Subject: RE: Springfield House - R230/19/PL

Paul Cann
Senior Engineer (Drainage & Coastal)

In the meantime I note that the Drainage Engineer has made the following comments : It is assumed that the pool is open and not covered. If it is covered then it will need to be accounted for in the Surface Water Drainage Design. This has not been confirmed.

Title			Proposed New Foul Drainage		
Scale	1:500	At original	A4	© Robert Clark Associates Ltd	
Drawing Number	1772/F/SK2		Revision		-

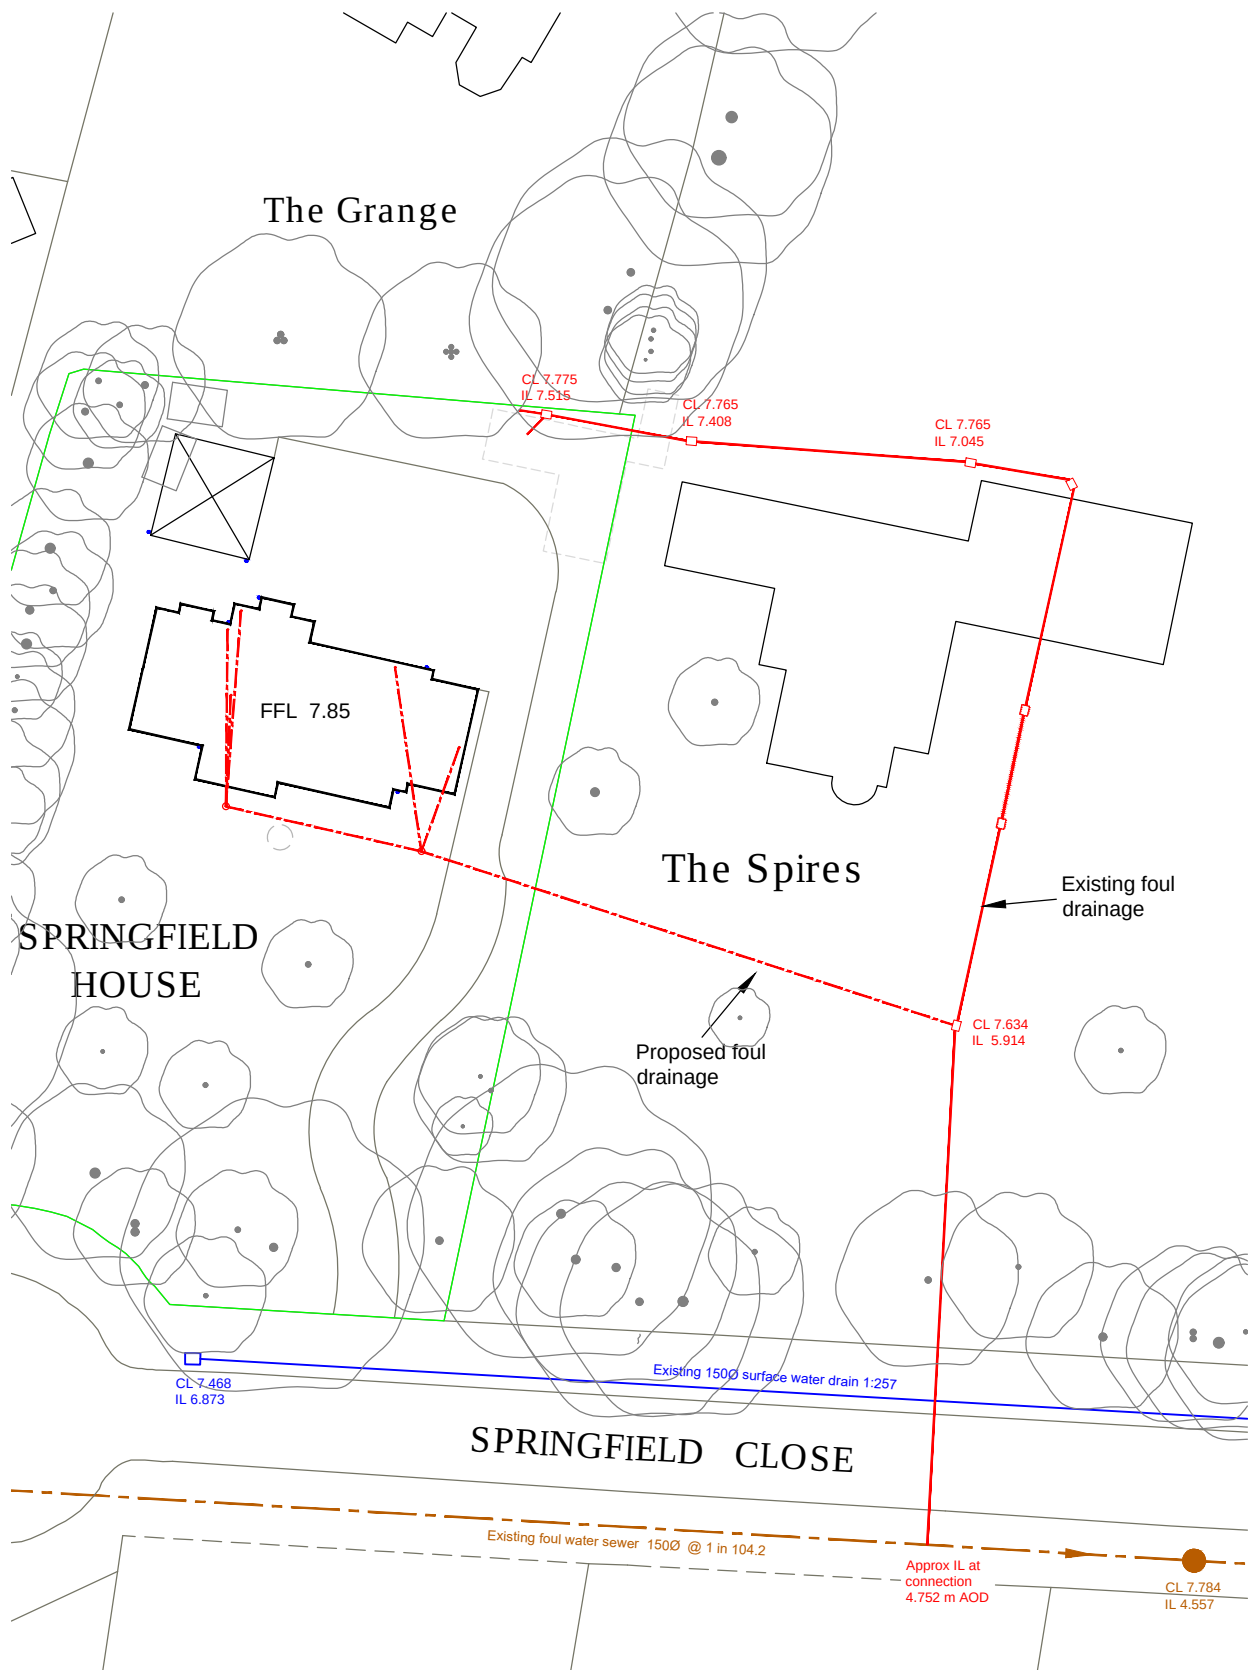
No information is given for how the pool will overflow and backwash. It is assumed that this will go to the foul sewer but this is not shown on the Foul Drainage Drawing. Southern Water will need to be consulted if this is the case. The foul drawing also shows the formally approved 2 bay garage which this application removes. The proposed 3 bay garage is not shown.

In respect to the pool and assuming it is open rather than covered, then as previously mentioned, it will not affect the surface water drainage design.

However, the pool will require a connection to the foul drainage system for emptying/backwash, etc reasons. I can confirm that Southern Water should be consulted in this respect in order to agree the connection and any associated emptying (time/flow rate) restrictions, etc.

Title			Foul Drainage Layout		
Scale	1:500	At original	A4	© Robert Clark Associates Ltd	
Drawing Number	1772/F/SK3			Revision	-

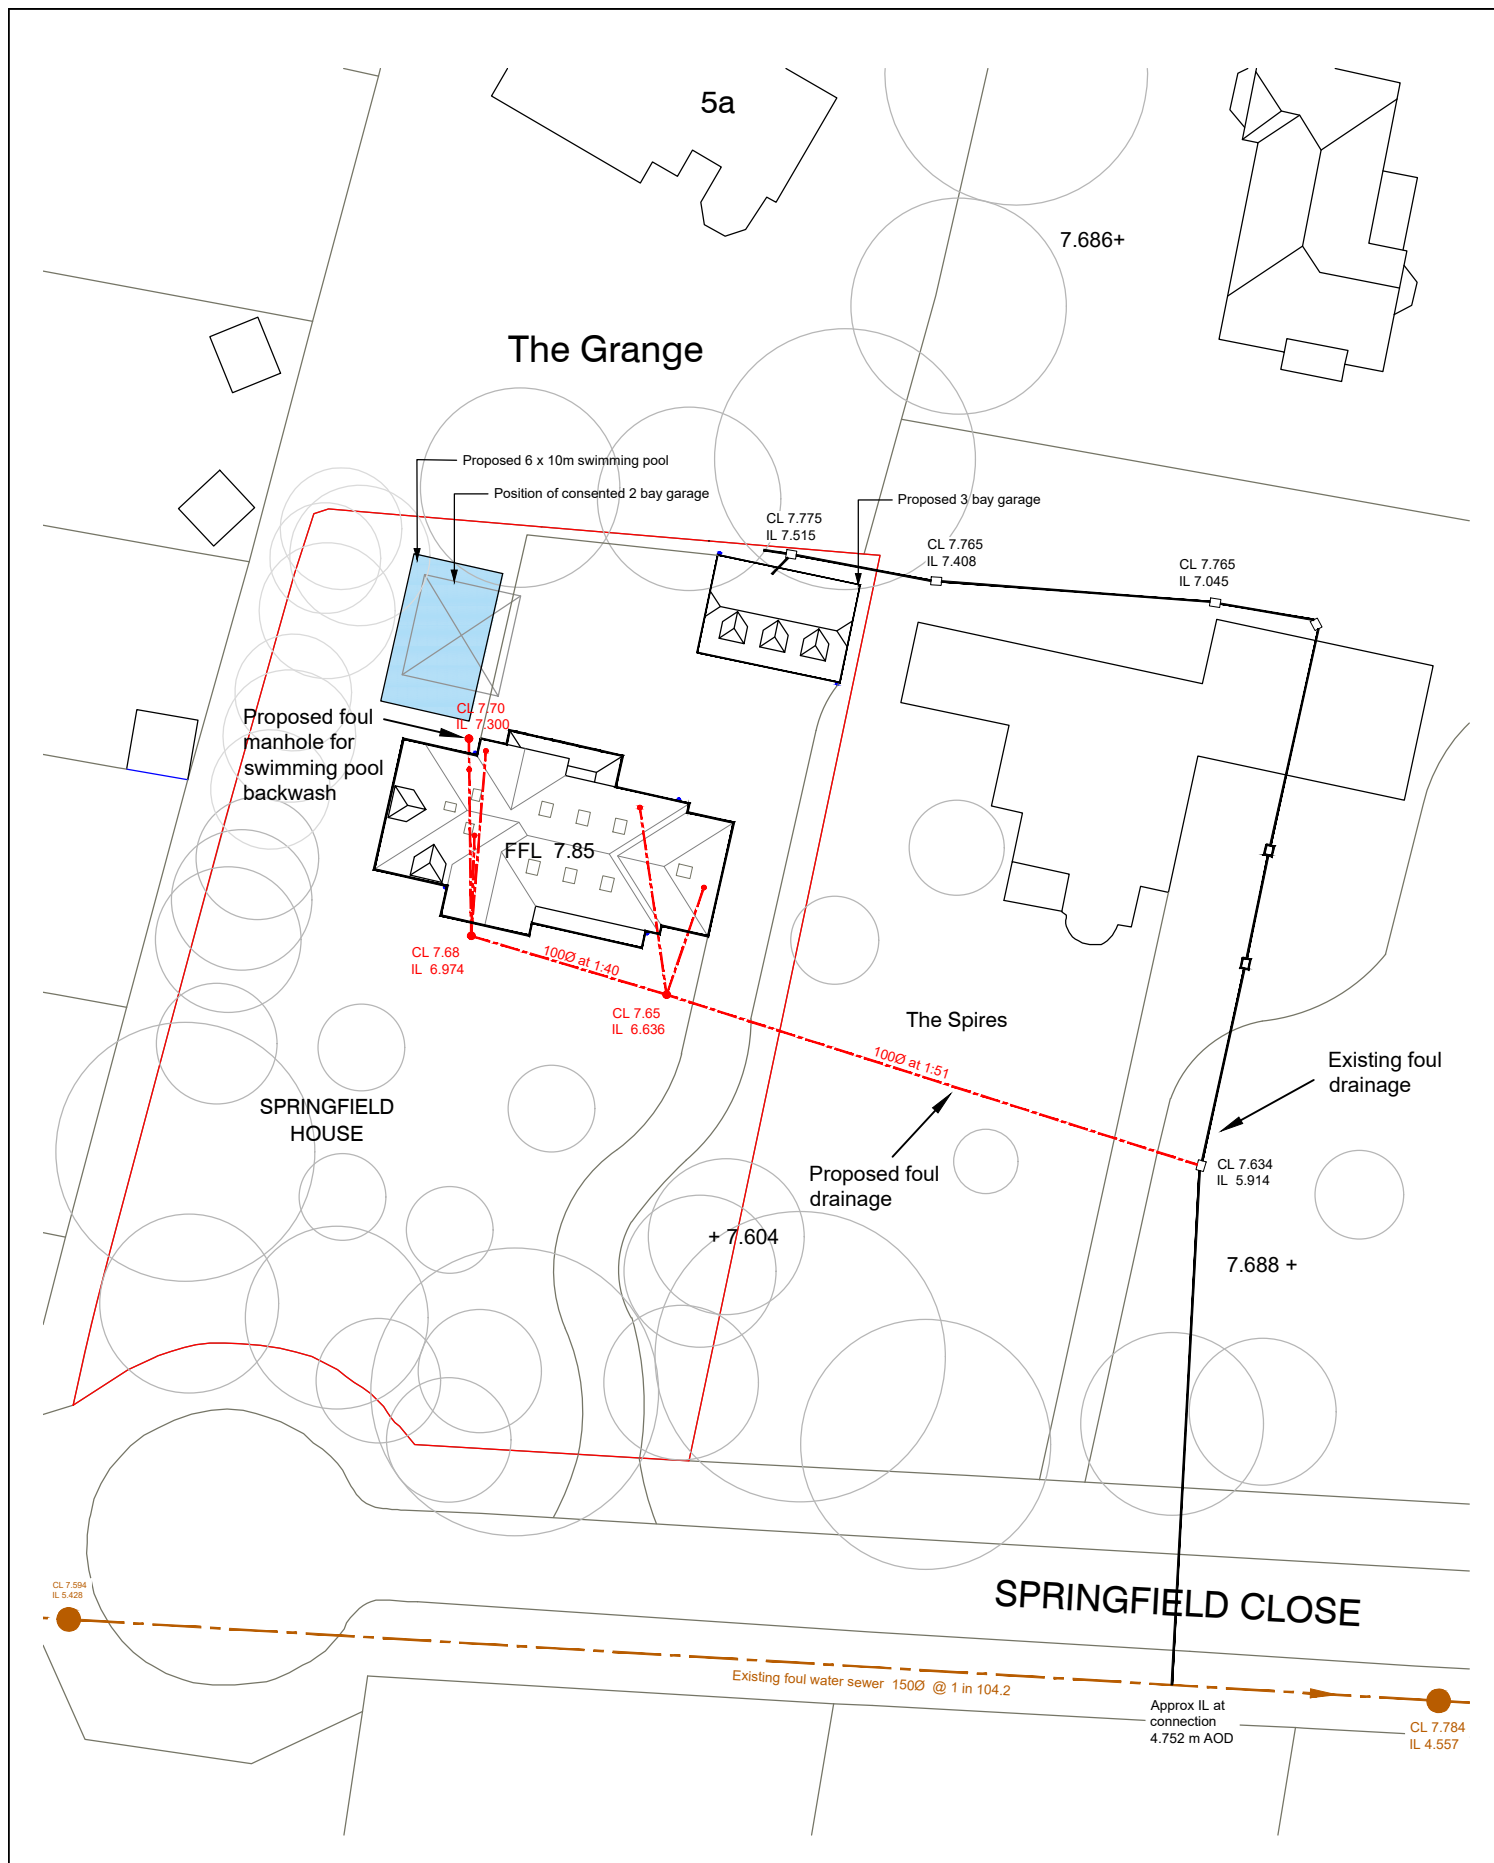
Please see revised Foul Drainage Drawing. Do you have any additional comments to make? Is it necessary to consult with Southern Water?

I have no further comments regarding the surface water drainage proposal, just a request that it is constructed in accordance with the drainage layout supplied. However, I cannot offer consultation on the pool. As such, I would suggest it is prudent to consult Southern Water.
